From: Michael Eastham <Michael.Eastham@arun.gov.uk>
Sent: 03 April 2020 15:58
To: Planning.Responses <Planning.Responses@arun.gov.uk>
Subject: FW: BN/85/19/DOC - The Lillies

Subject: RE: BN/85/19/DOC - The Lillies

I have received the email below from the applicant for BN/85/19/DOC at the Lillies, Yapton Road in Barnham.

Comments on proposals;

TYPICAL CROSS SECTION ACROSS PERMEABLE BLOCK PAVED DRIVES INCORPORATING IMPERMEABLE BLOCK PAVED SERVICE CORRIDOR

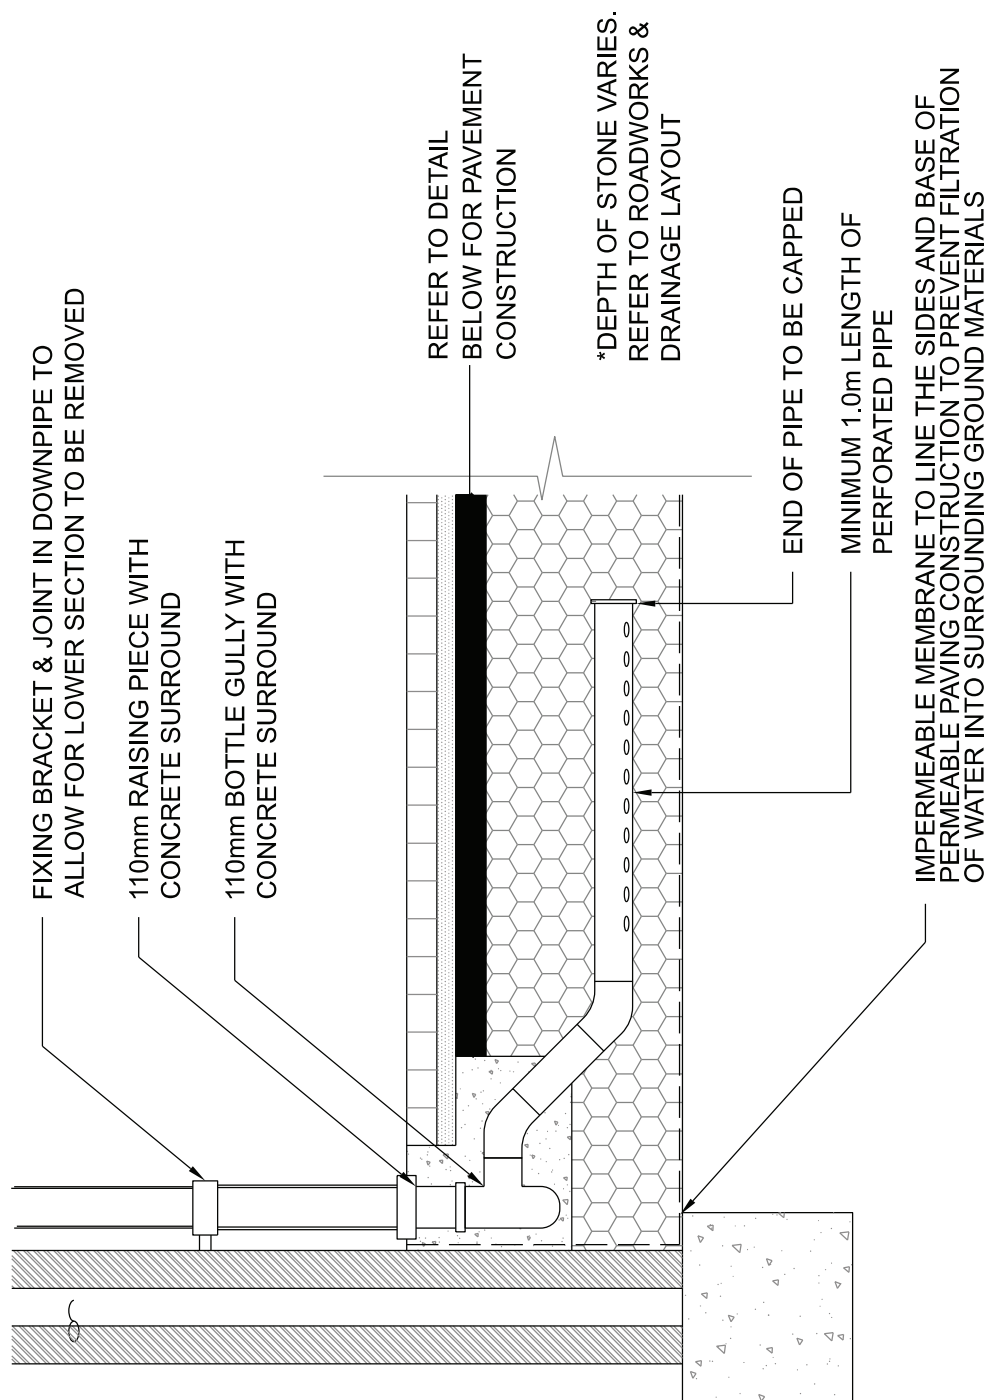
12. Where the existing public foul sewer gravity sewer and rising main passes beneath the permeable pavements, are you proposing the service corridor construction arrangement – If so, detail how water can flow between the separate sub bases. *Detail added.*

RAINWATER DOWNPIPE DIRECT CONNECTION TO PERMEABLE PAVING

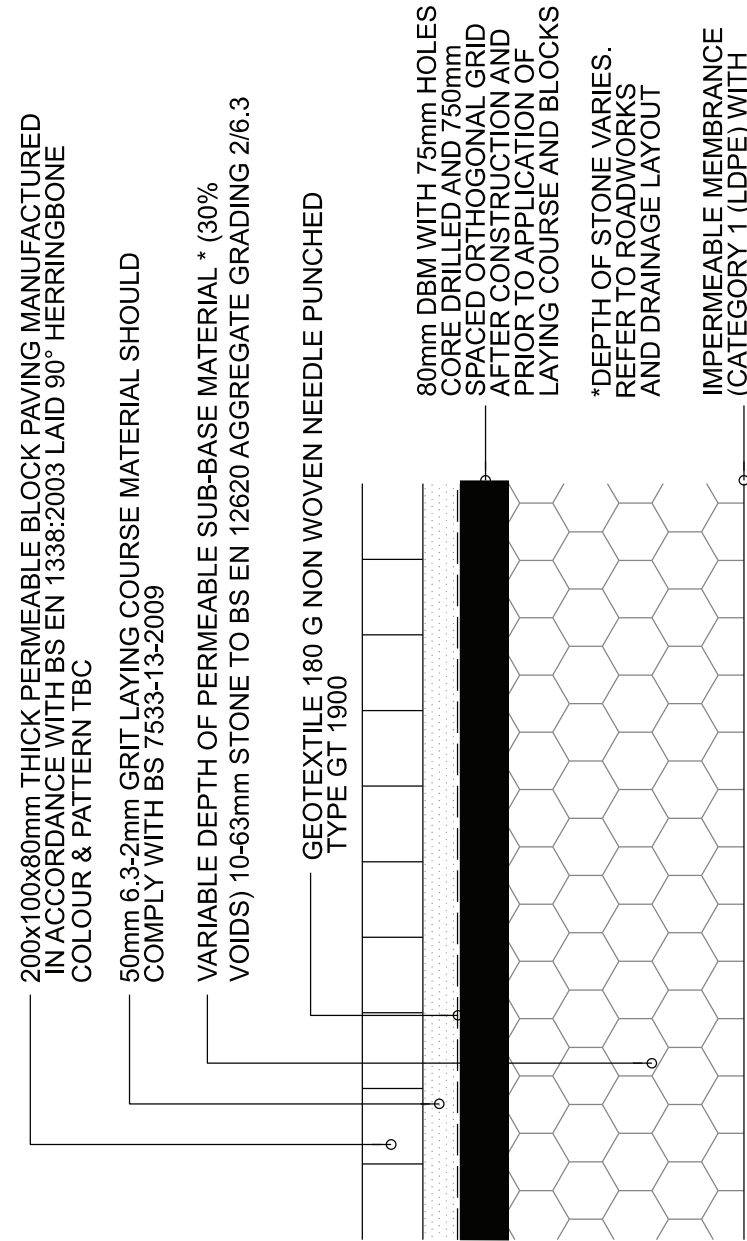
6. All discharges into permeable pavement structures will need to be connected via a diffuser unit and a catchpit manhole incorporated upstream of each unit. Any bends to incorporate a manhole. Construction details to be provided for the diffuser units and catchpit manholes. Specify pipe invert levels at the diffuser unit and the manholes. Specify pipe diameters on all connections. Having looked into this following your comments, the interpave document only requires diffusers for large areas. The areas we are designing are not large and the detail we have proposed has been accepted by countless counties and associated building control, including sign off from NHBC and Premier.

SFA10A Althon Pre-Cast Headwall

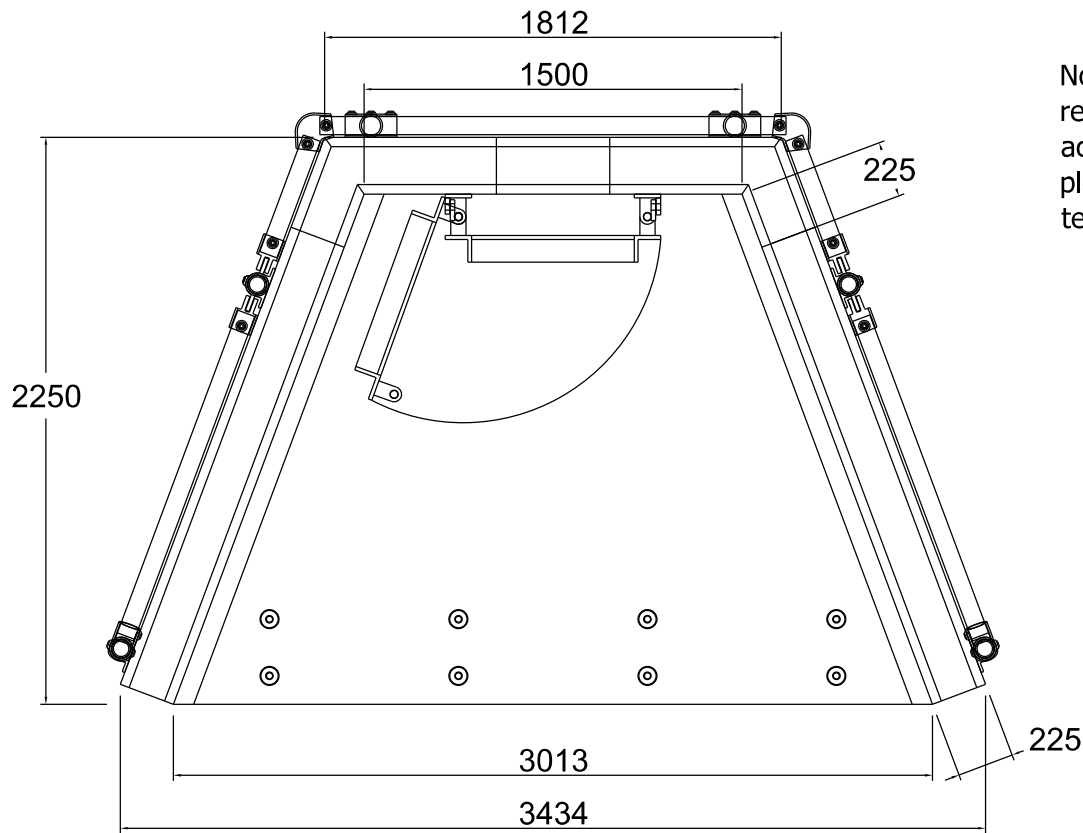
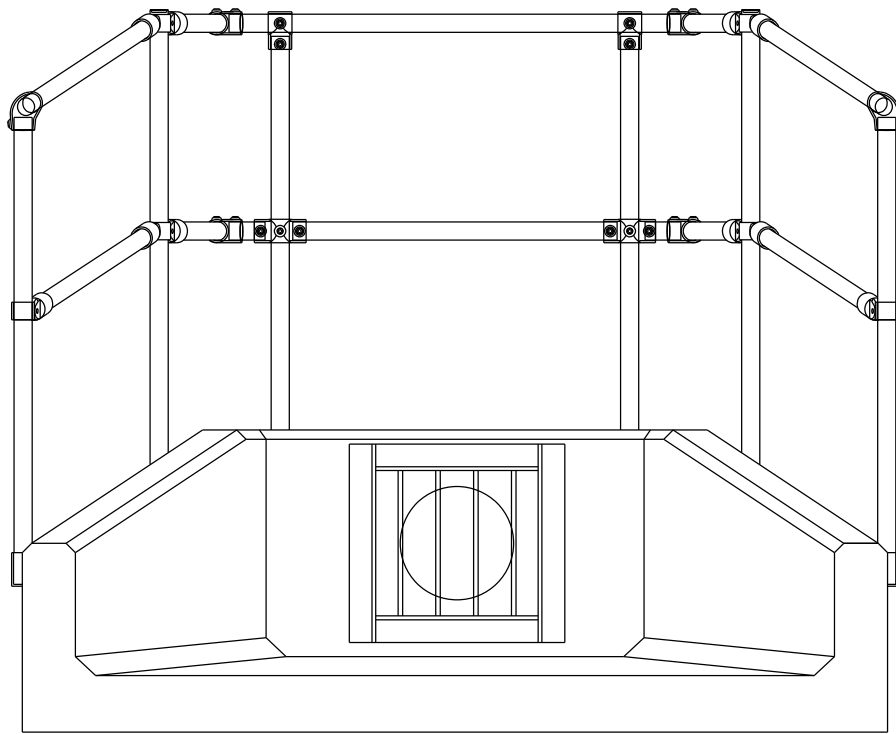
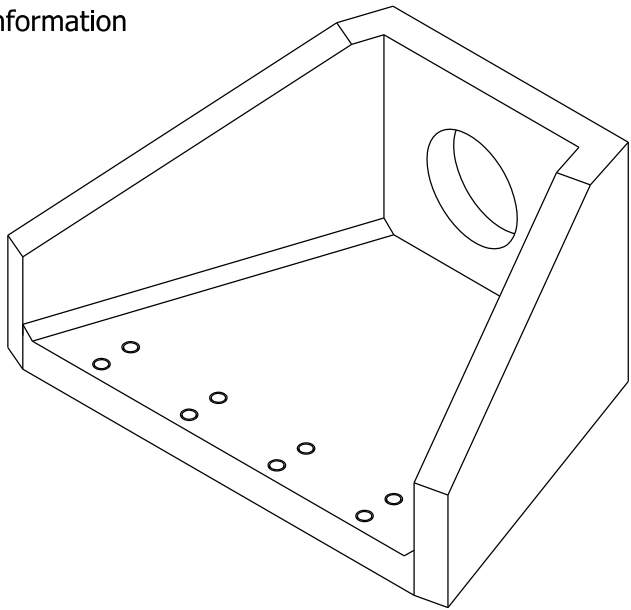
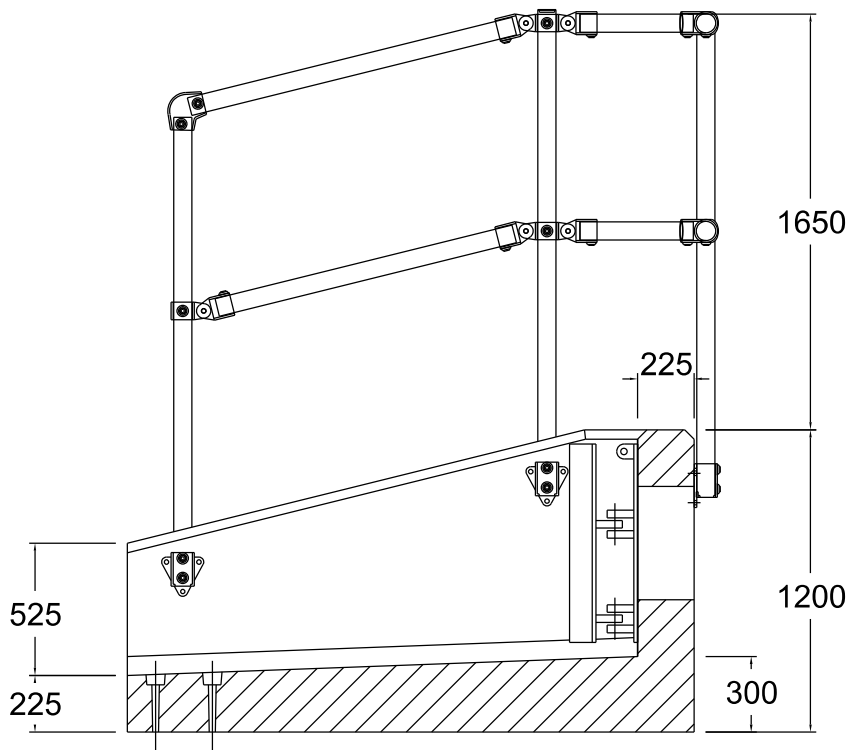
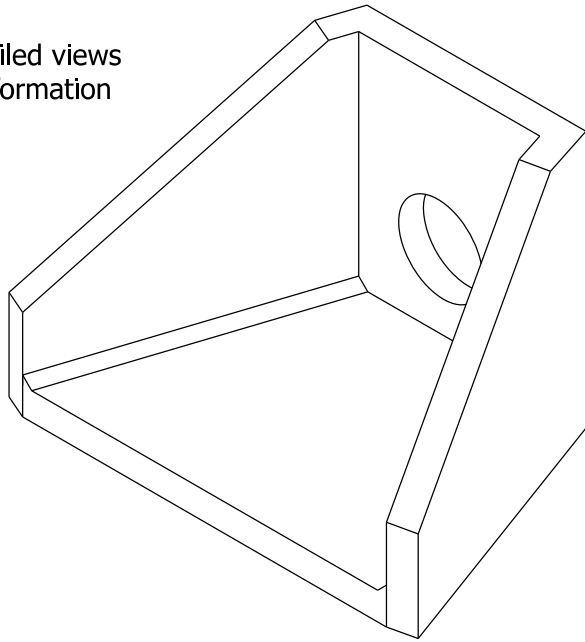
27. Headwall SFA10A incorrectly specified for the pond headwall – this should be SFA10C and SFA10A specified for the discharge to the ditch. Adjusted
28. Pond headwall – specify a ‘cranked’ grille to suite a 450mm pipe. Banks in vicinity of headwall to be profiled to suit wing walls – add note. Added
